CITY OF ALBUQUERQUE
PLANNING DEPARTMENT
DEVELOPMENT REVIEW BOARD

Project# 1008656

**CITY OF ALBUQUERQUE
PLANNING DEPARTMENT
July 16, 2014
DRB Comments**

RE: Tracts A & B, Estates at Glendale

ENGINEER'S SEAL	GLENDALE ESTATES UNIT 2	DRAWN BY WCWJ
	SKETCH PLAT	DATE 2-08-11
DAVID SOULE P.E. #14522	 Rio Grande Engineering 1606 CENTRAL AVENUE SE SUITE 201 ALBUQUERQUE, NM 87106 (505) 972-0998	2119-LAYPUT-6-01-10
		SHEET # 1
		JOB # 2119

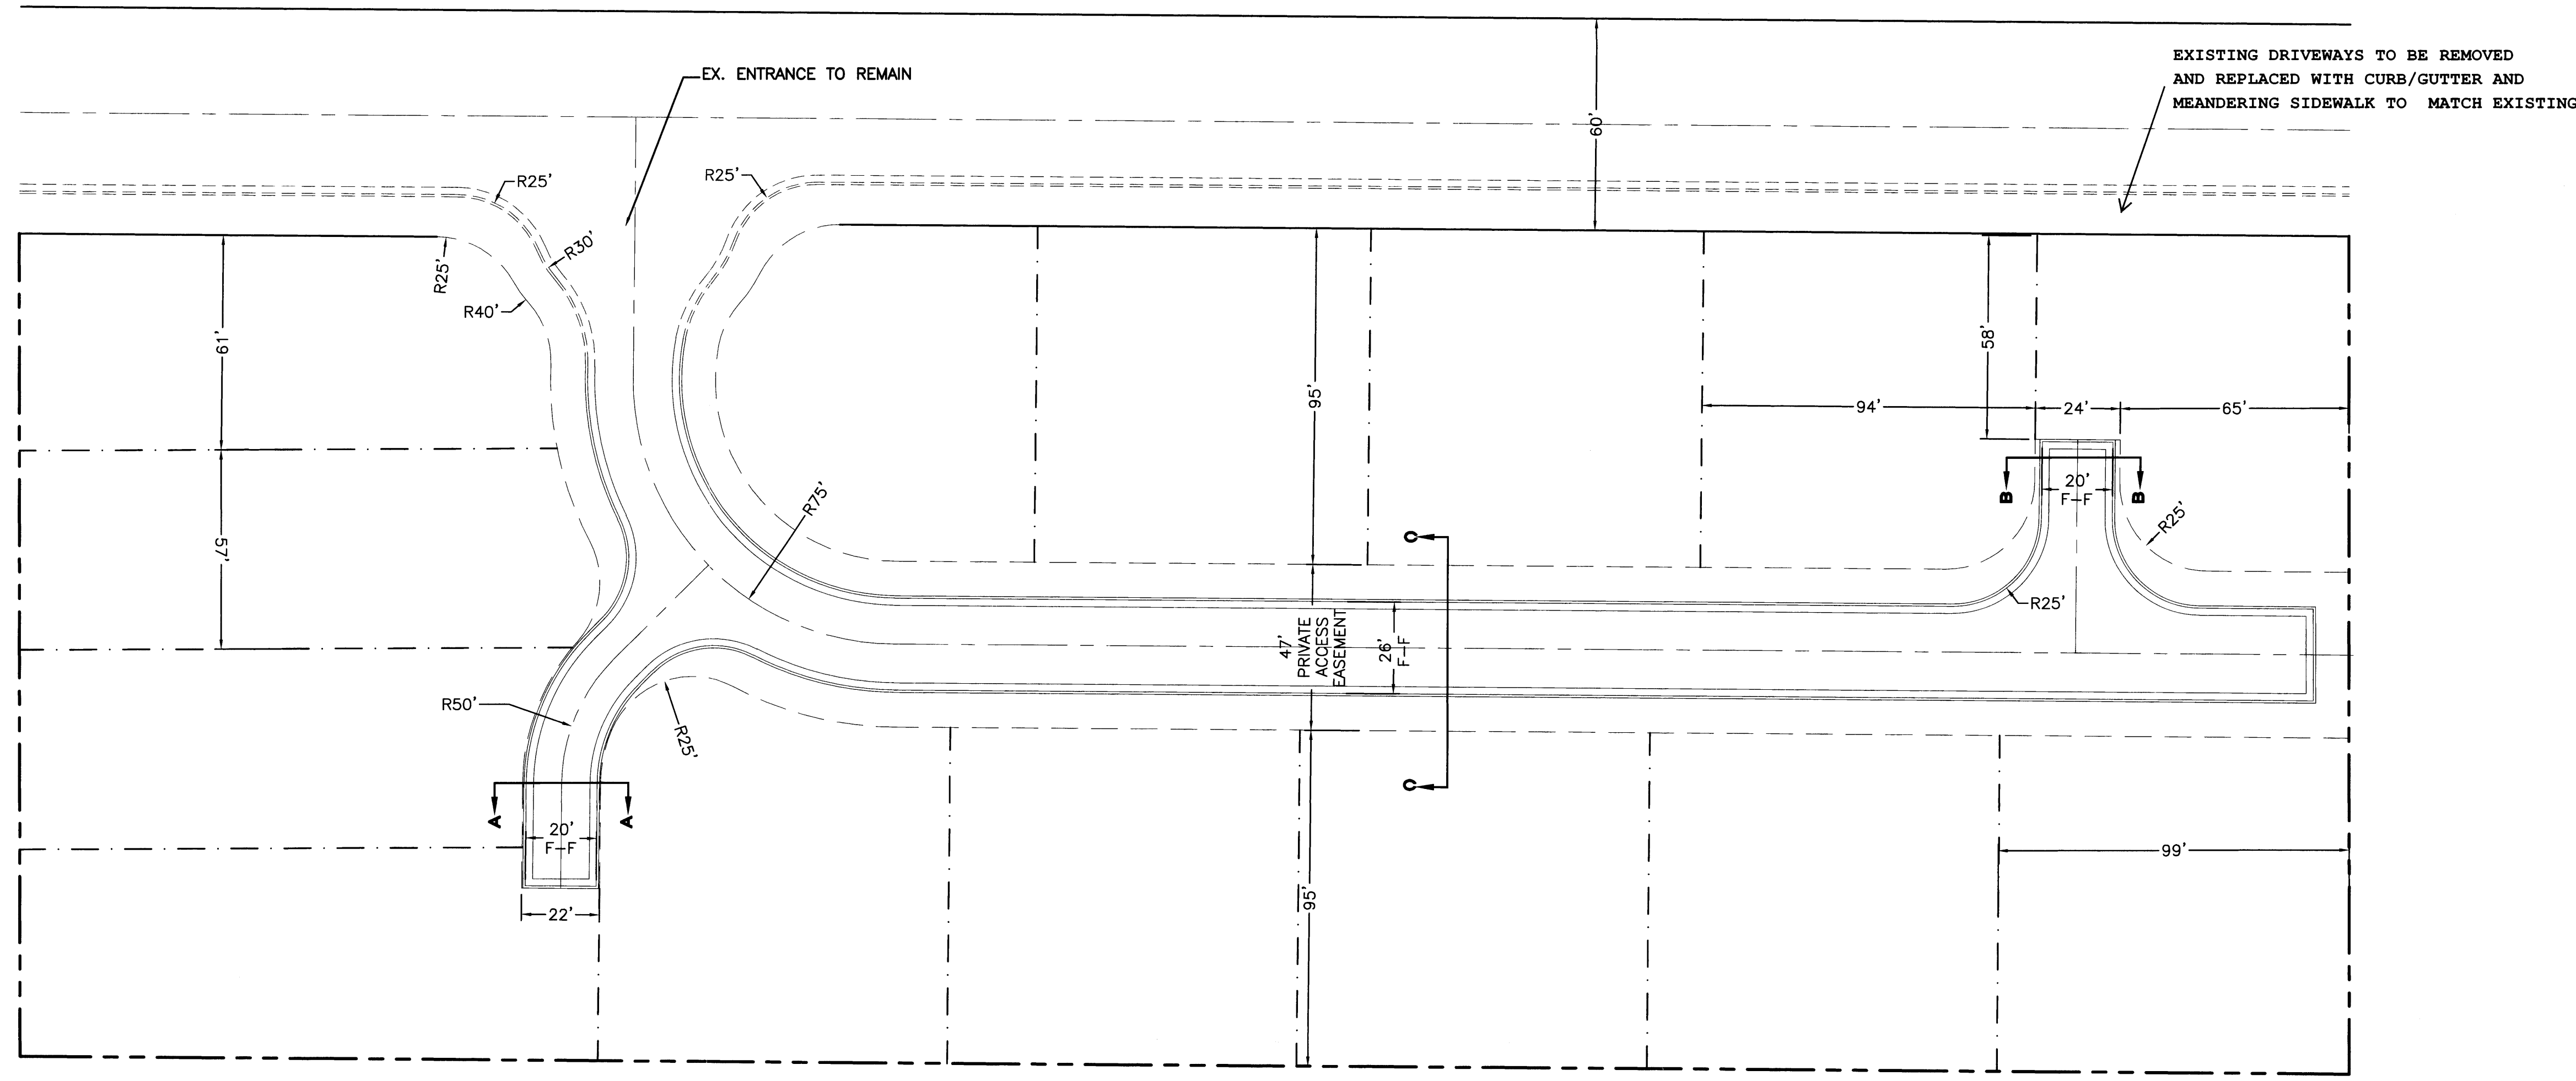
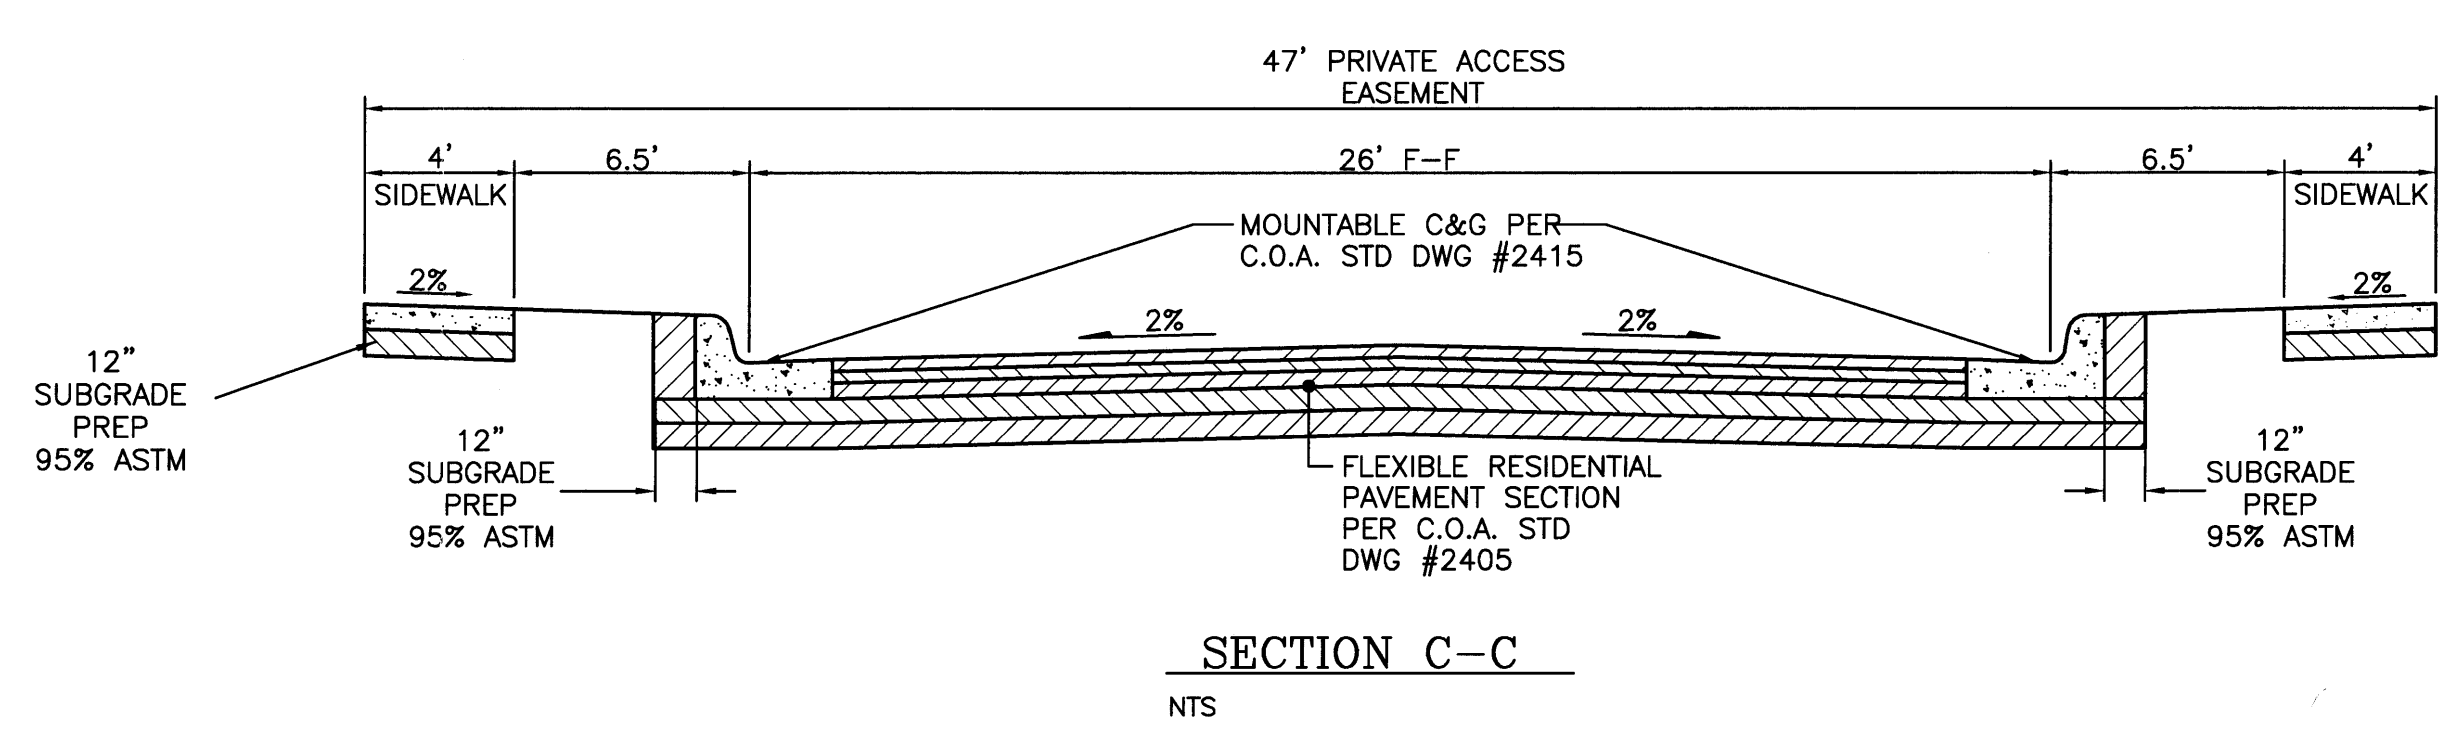
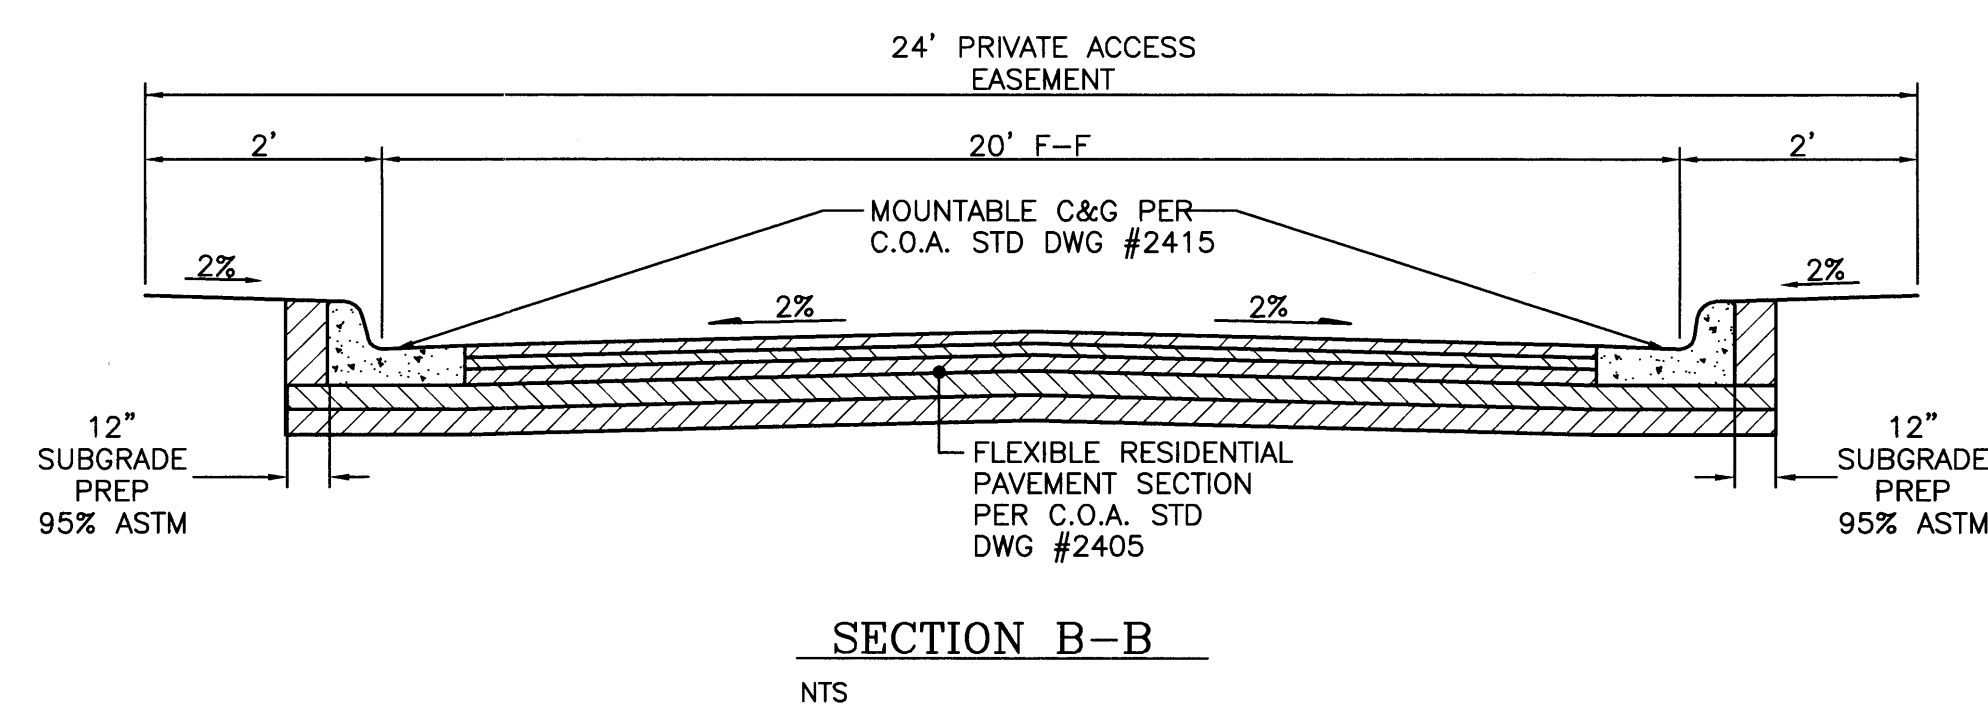
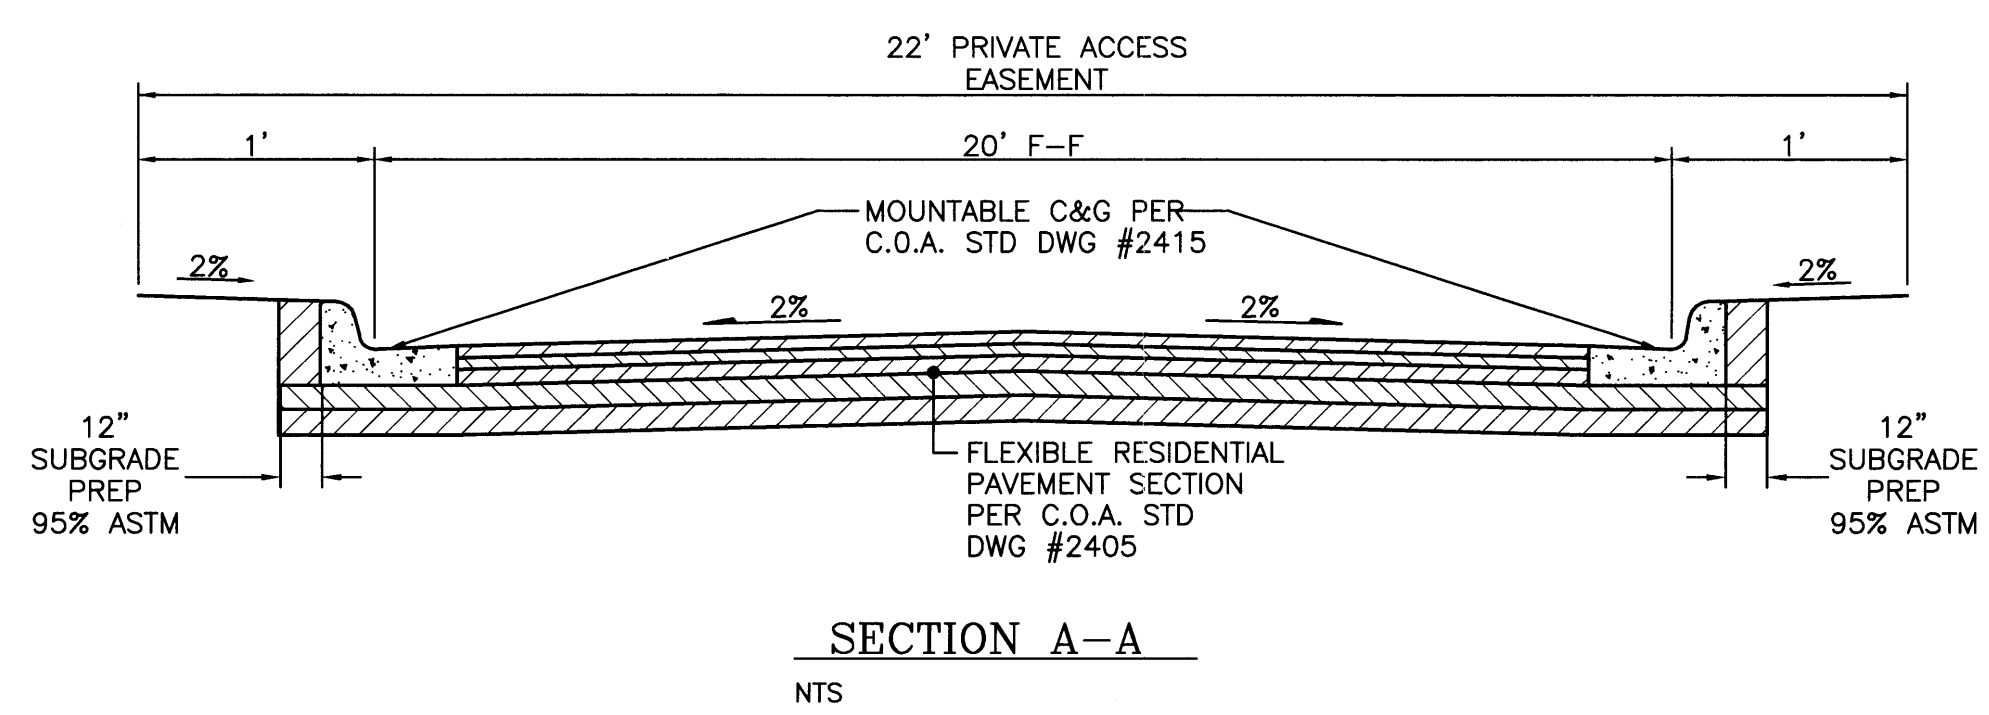
A DPM standard hammerhead is needed at the east end of proposed main street, and a sidewalk is needed on west side of proposed stub street.
